REQUEST

Current Zoning: R-3 (single family residential)
Proposed Zoning: R-8MF(CD) (multi-family residential, conditional)

SUMMARY OF PETITION

The petition proposes to allow up to 200 single family attached (townhome) residential units on a property containing an existing single family home that will remain and is located outside of the rezoning boundary in East Charlotte.

SHEET NUMBER  
RZ-01

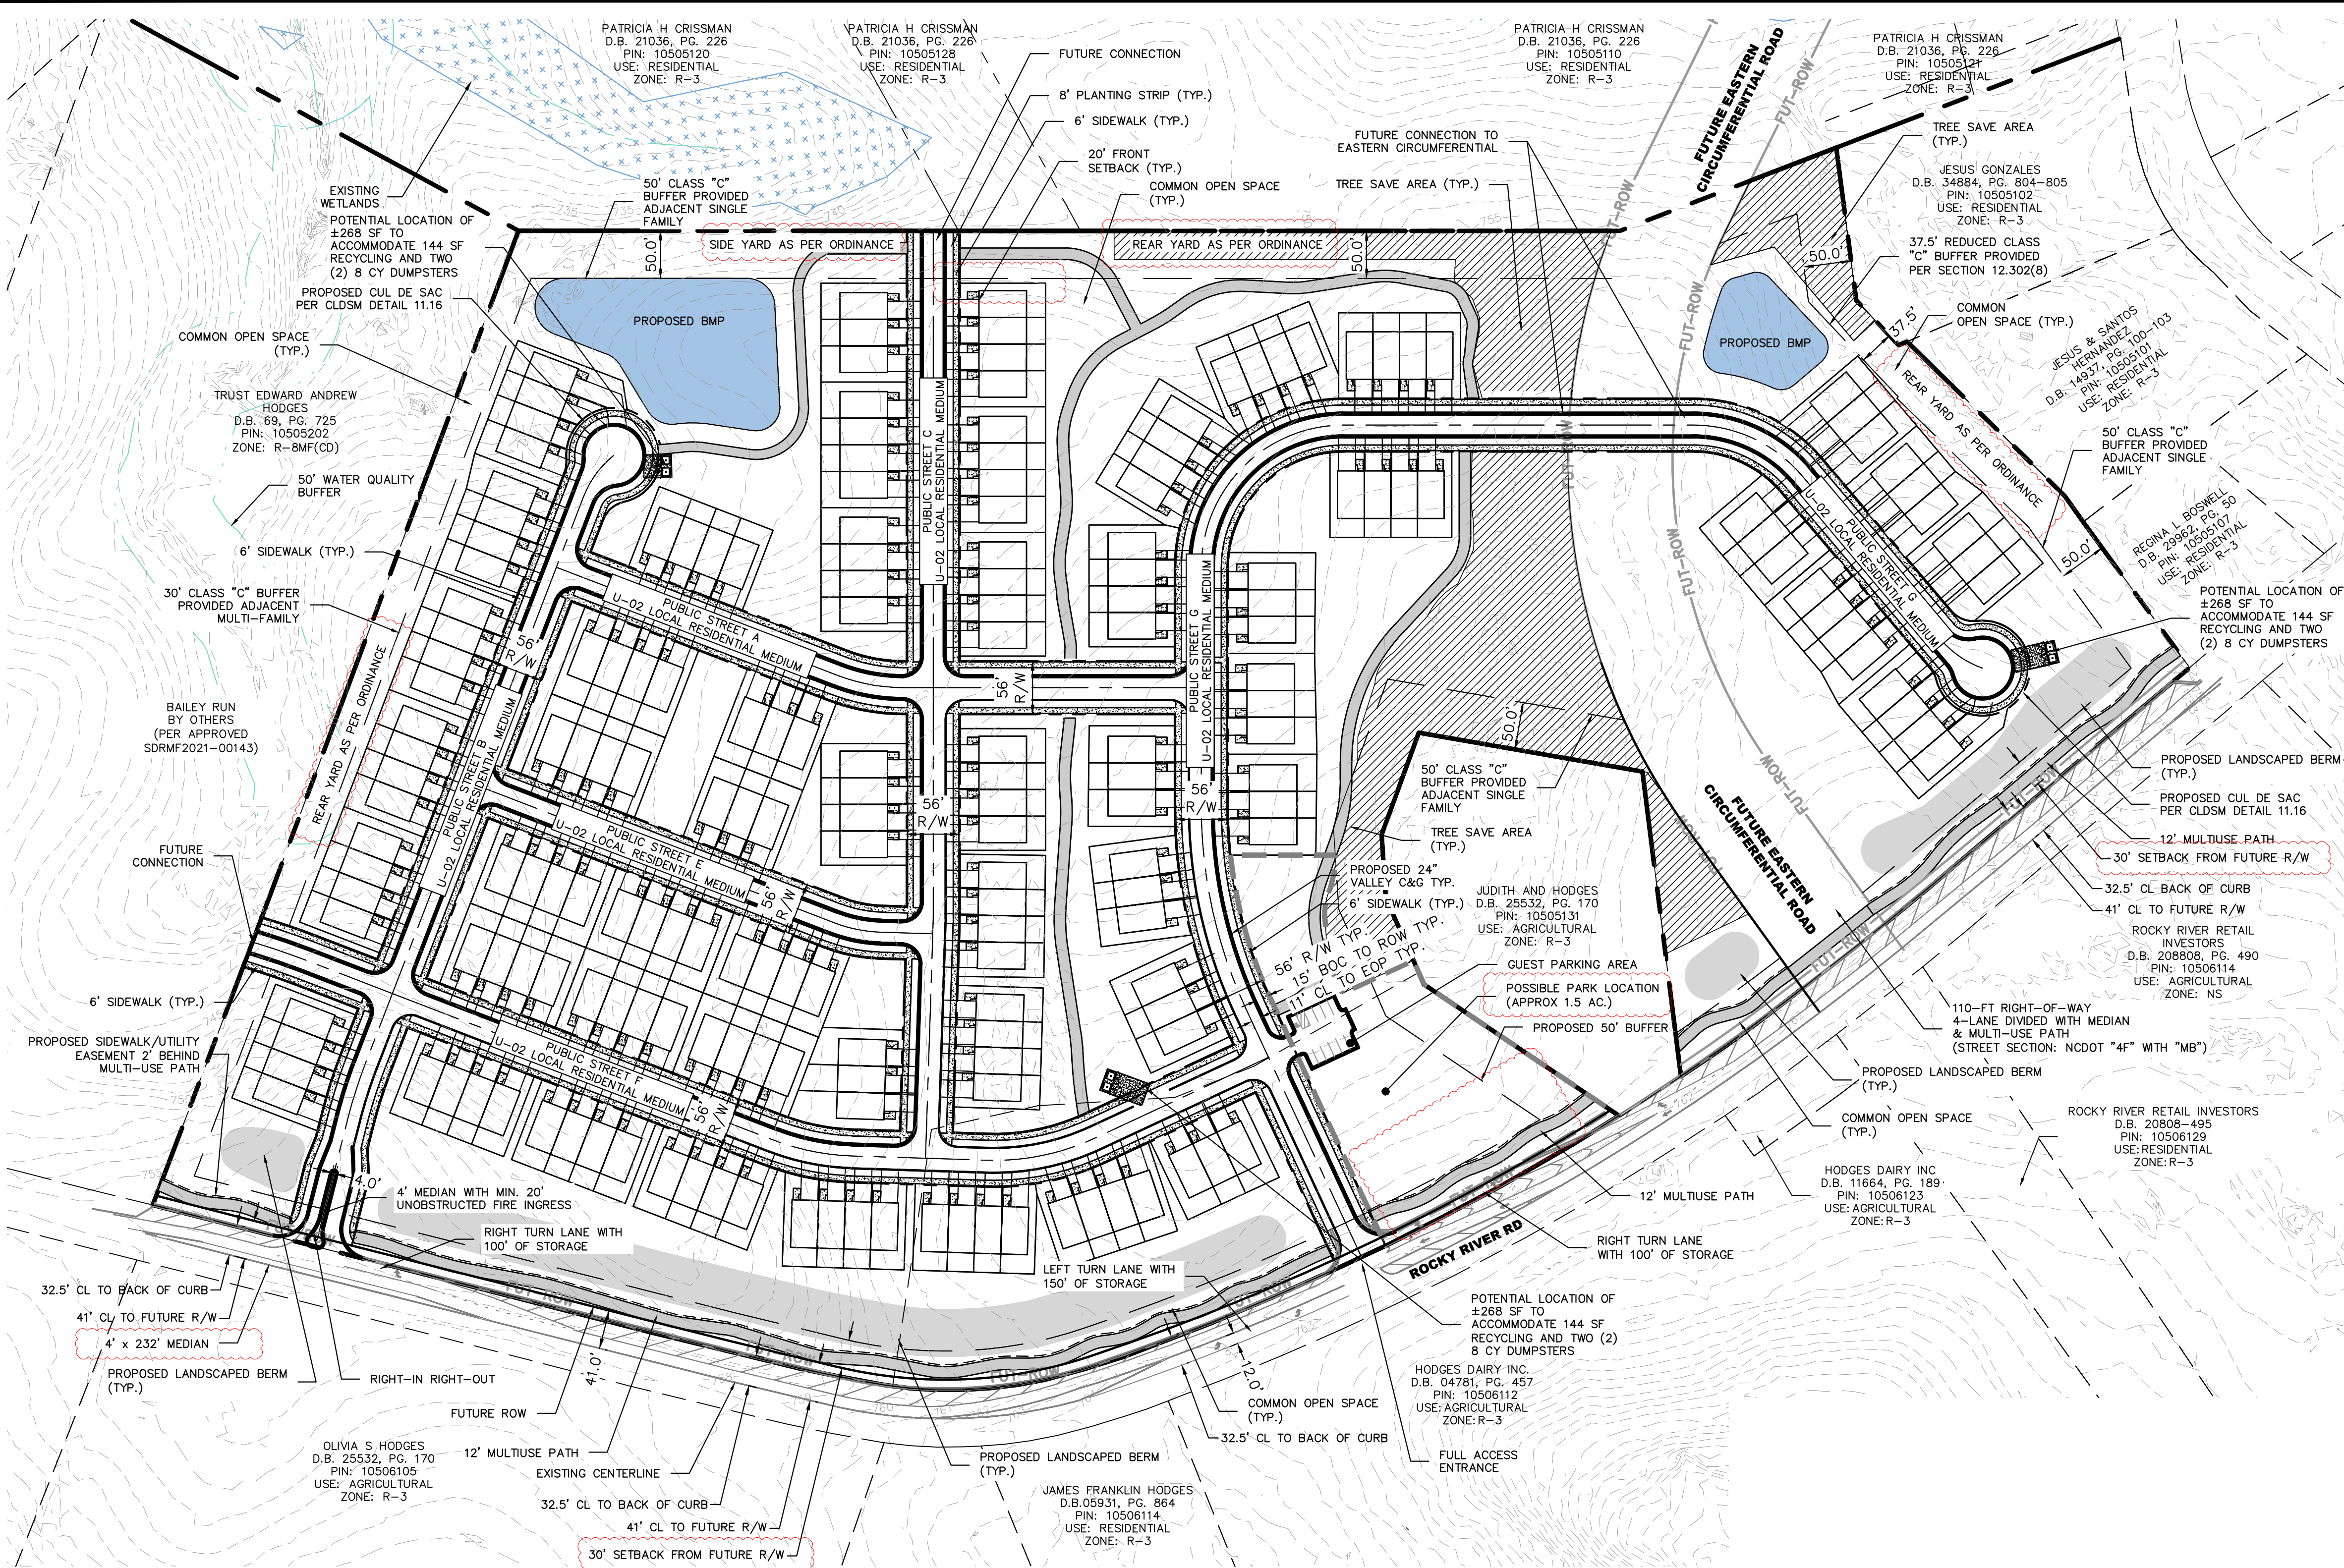
21. Development Data Table references the 50-foot Class C buffer, but not the 30-foot Class C buffer provided adjacent multi-family. Not addressed
22. **New comment resulting from revised site plan dated 5/18/2023:** Previous site plans submitted state total 38.25 acres, while most recent plan states 42.46 acres. Please confirm which acreage is correct.

23. New comment resulting from revised site plan dated 5/18/2023: Add to Site Data Table – "15 ft. setback per Section 9.303(19)(f) of the zoning ordinance. Not addressed
